498 St. John St.

Duplex

March 9, 2004

RE: Application for Minor Site Plan, 498 St. John Street
(CBL#079C001) (ID#2004-0029)

Date By: WJS	Date: JAN 22, 2004	Scale: 1" = 10'
Drawn By: WJS	Scale: 1" = 10'	Drawn No: 017

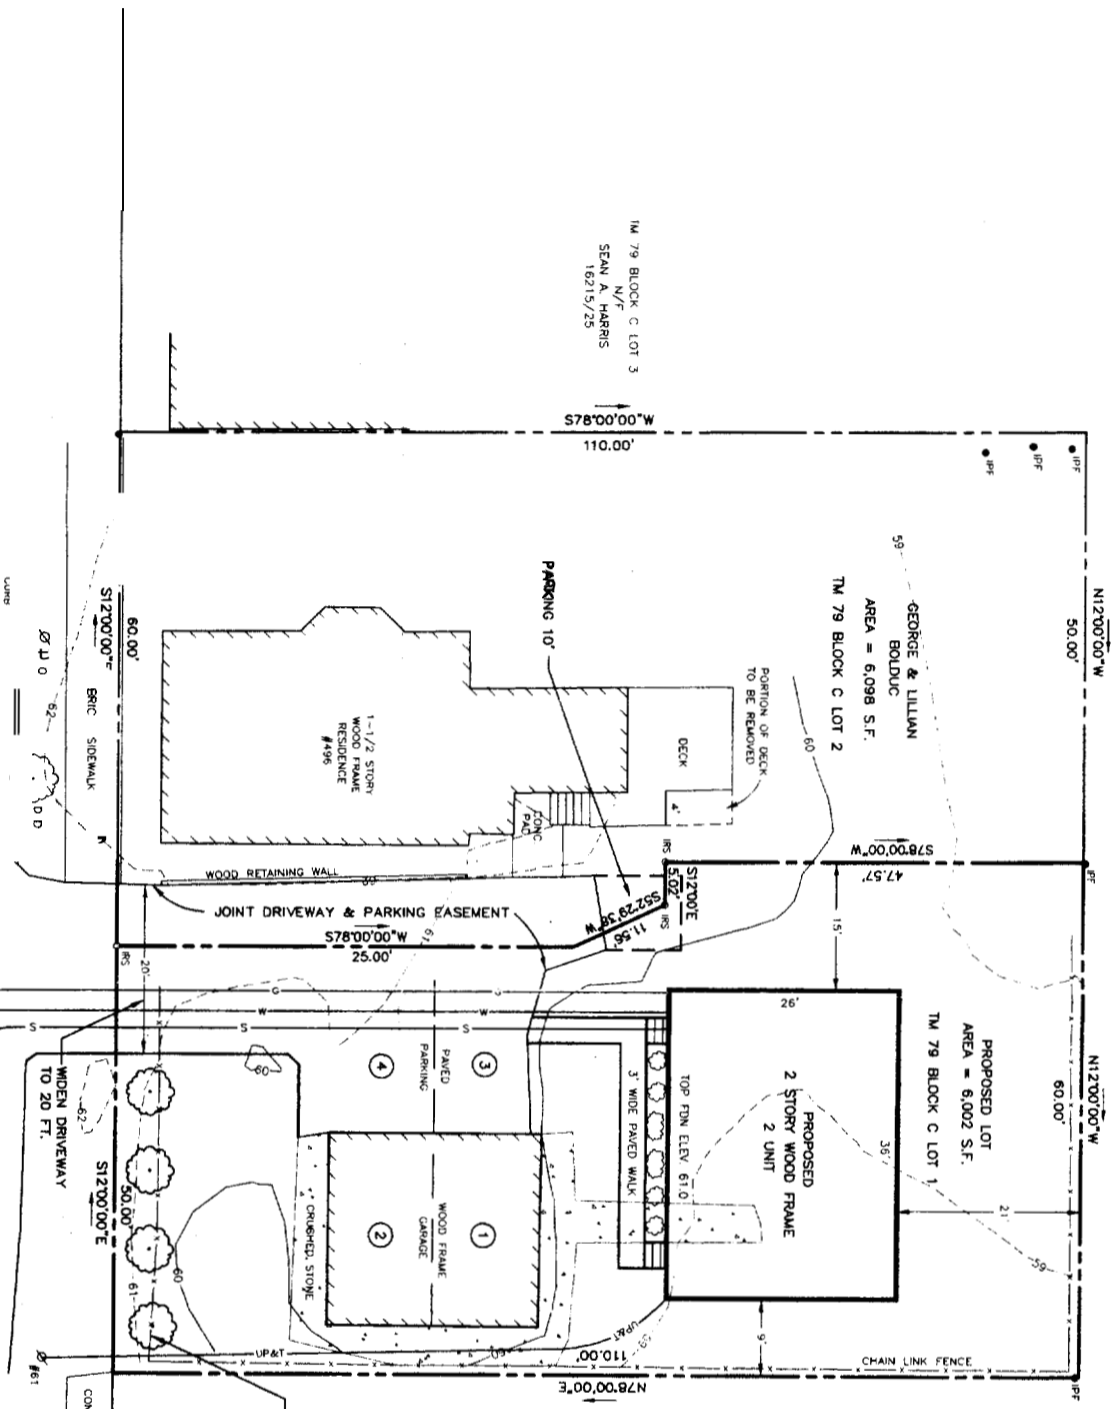
- i. Please indicate whether there are any proposed changes in the topography.
 - ii. A cleanout is required on your sewer lead (>80 feet from sewer main).

- iii. Are any foundation drains proposed? If so, please show the discharge/outlet location.
 - iv. Landscaping: Please indicate the species and caliper of street trees and foundation plantings that are shown on your site plan.

- v. Parking: The zoning administrator has indicated that a total of 5 parking spaces are needed to facilitate both properties. The 10' paving extension may need to be extended further. Also, a copy of the executed access easement will be required prior to obtaining a certificate of occupancy.

- vii. Curb and Sidewalk: Attached are the criteria for waiving curb and sidewalk. Please indicate which criteria are being met, so that the City may review the waiver.

Drawn By	WCS	Date	JAN. 22, 2004	Job No.	2002-034P
Trace By	JLW	Scale	1" = 10'	Draw. No.	2
Check By	WCS				
Book No.	937

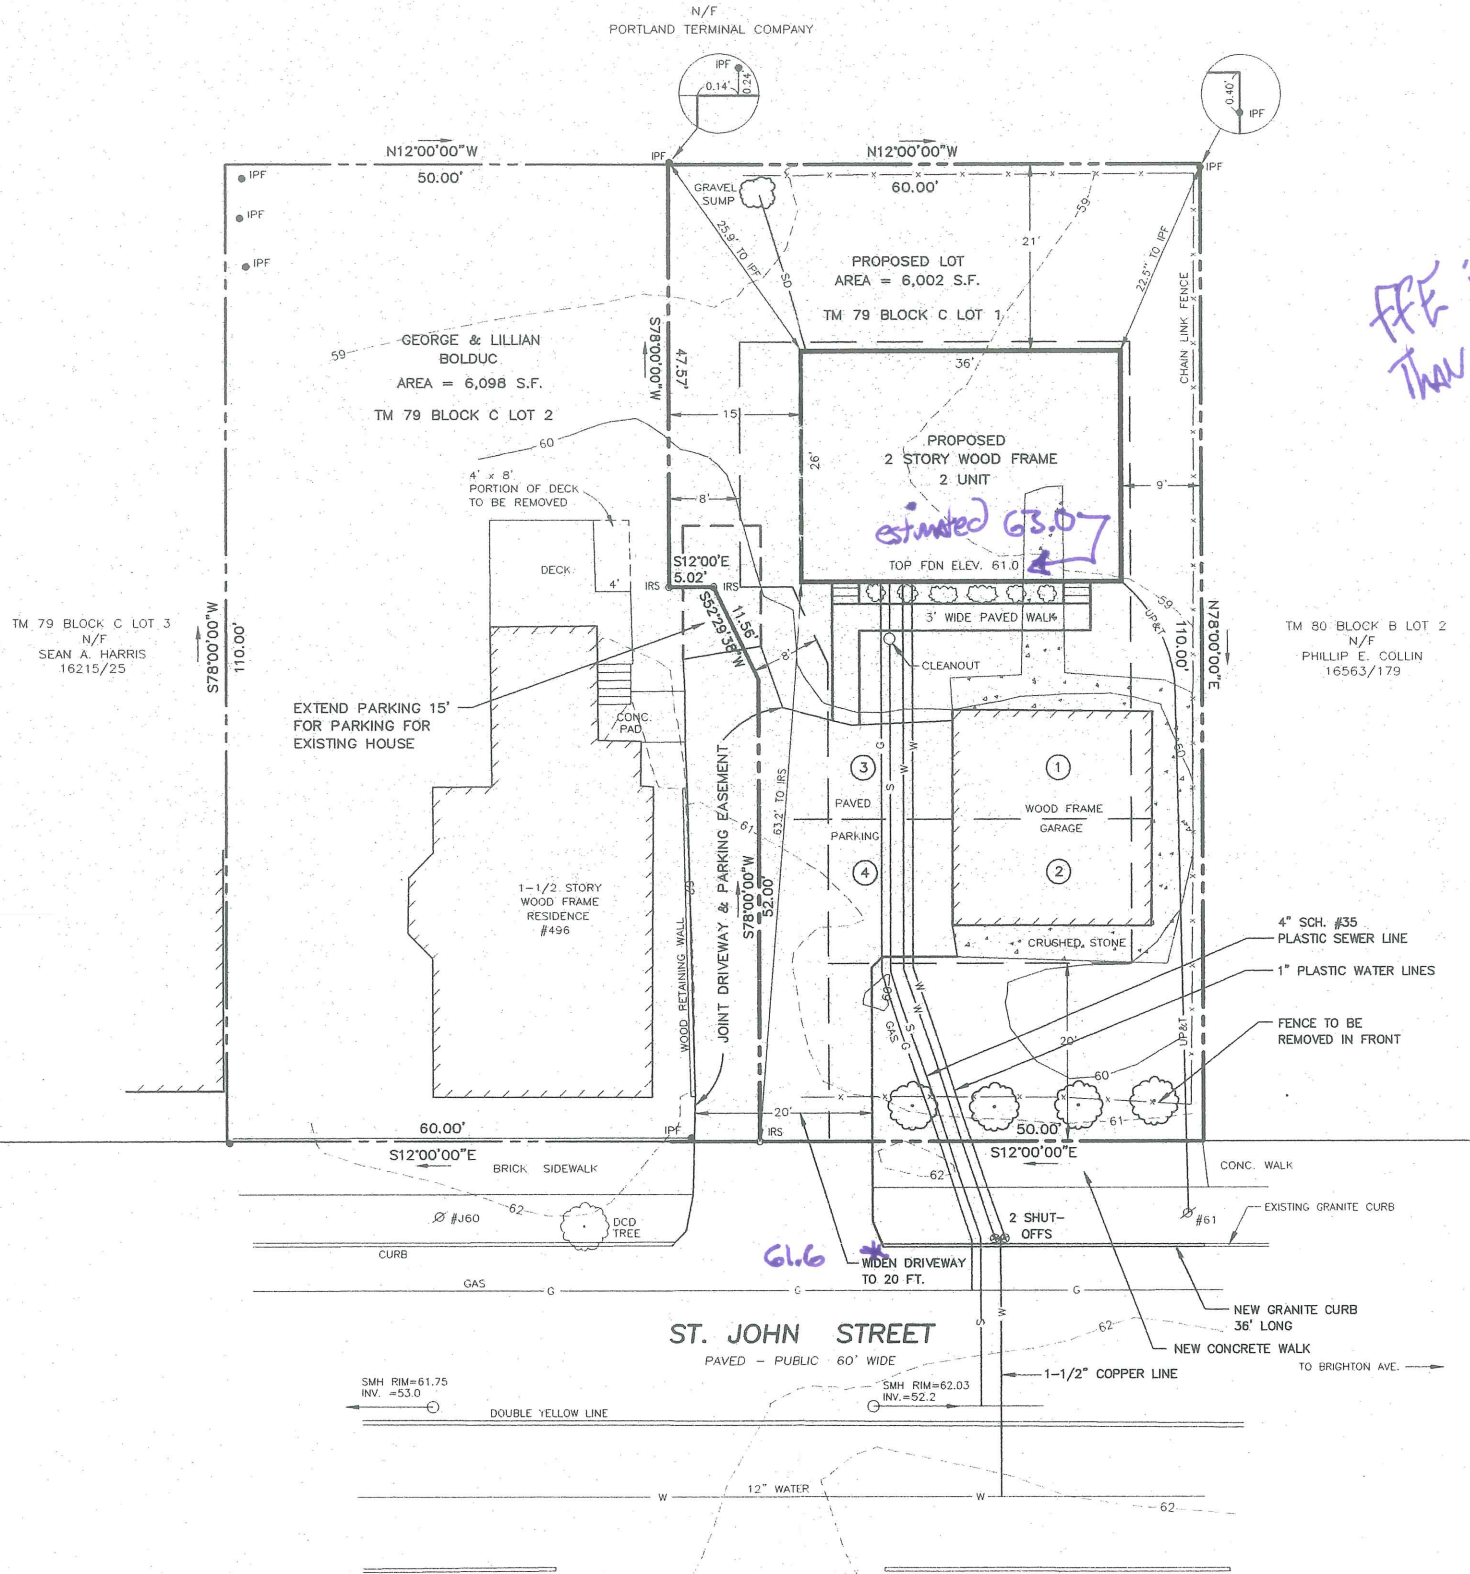
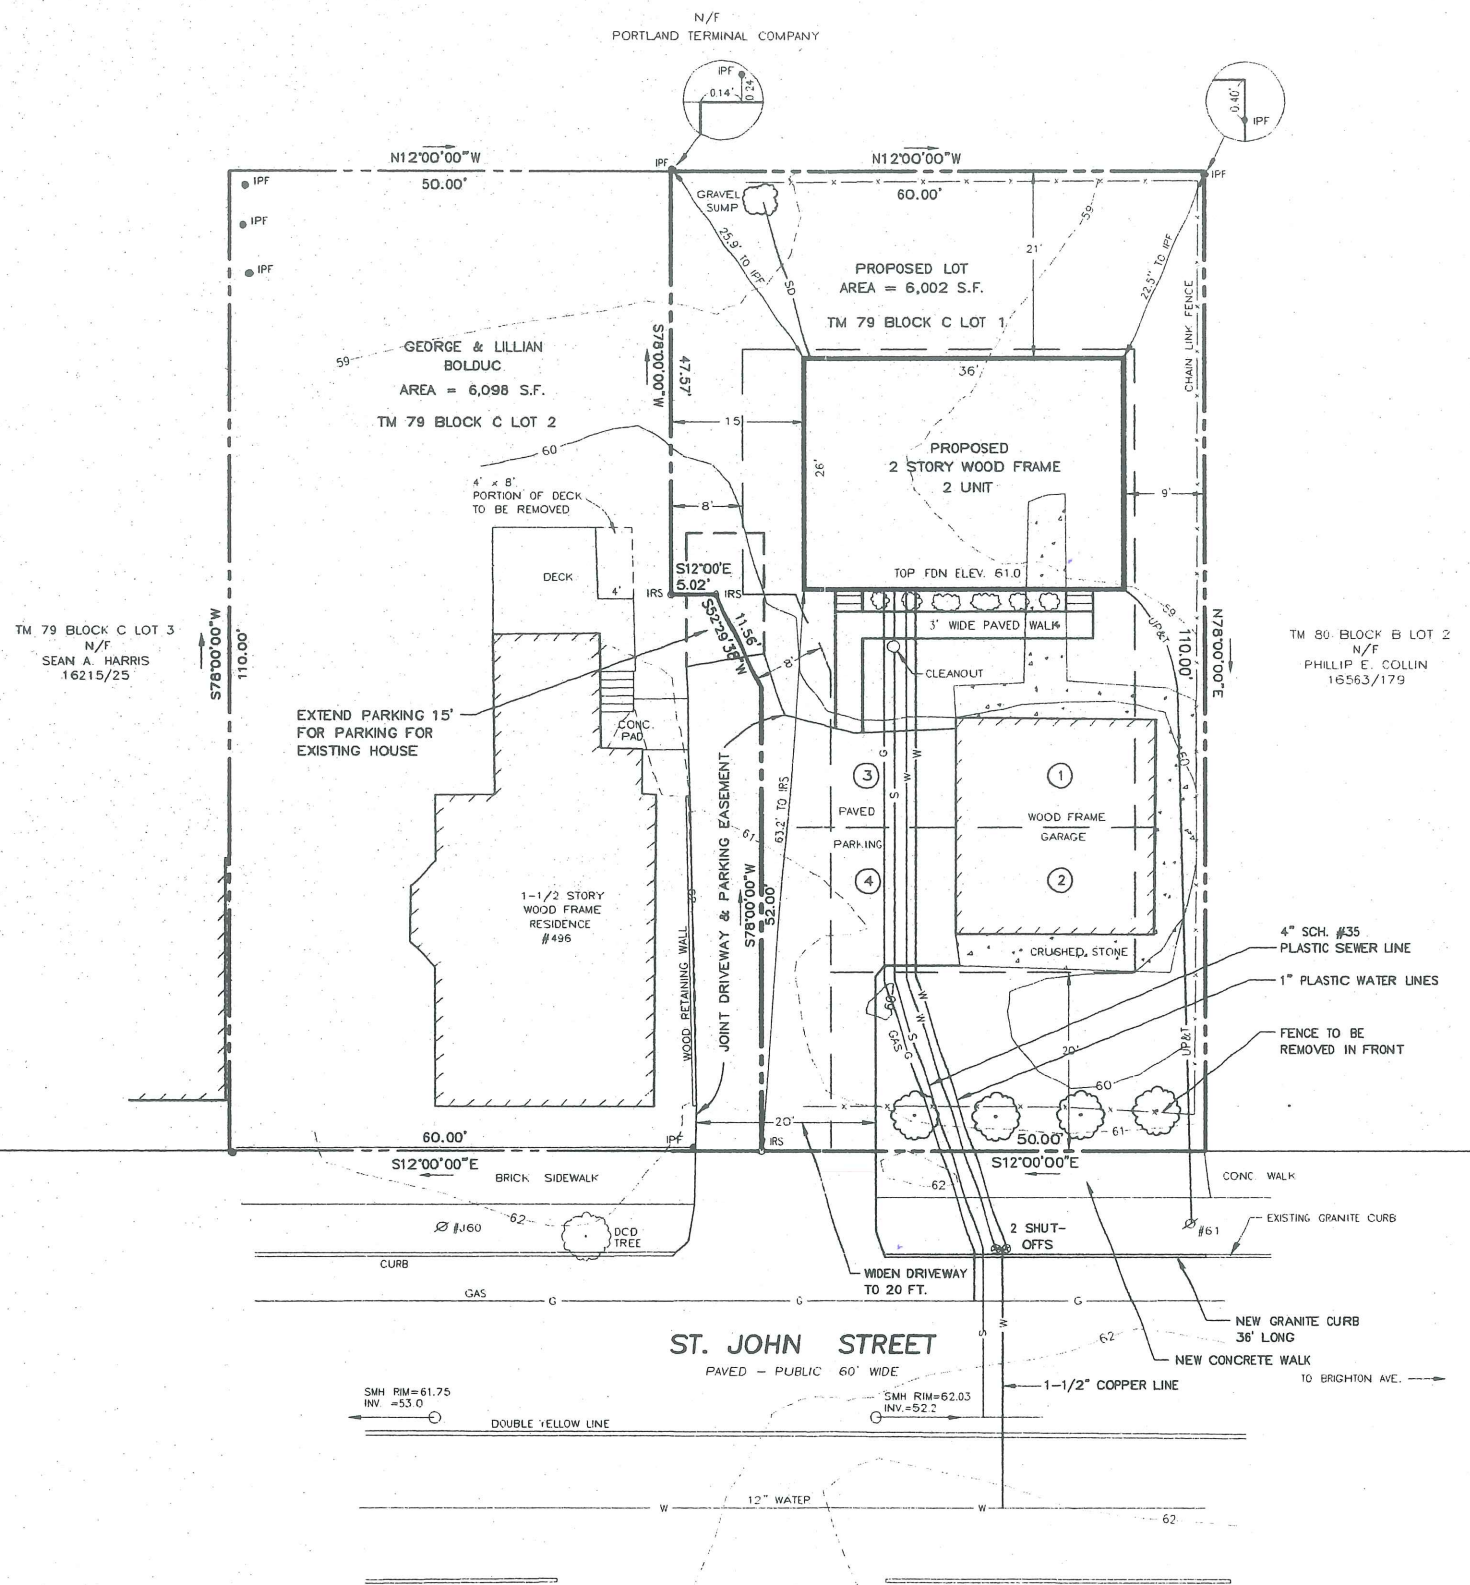
At a recent site visit, it was observed that the elevation of the proposed building appears to be higher than the proposed elevation on the approved site plan.

It appears that the foundation elevation has been elevated approximately 2 feet. As a result, changes in topography/grade have been done, which are not shown on your approved plan.

Because your buildout is not in accordance with your approved plan, a revision to your site plan is required. This revision should address these discrepancies listed above.
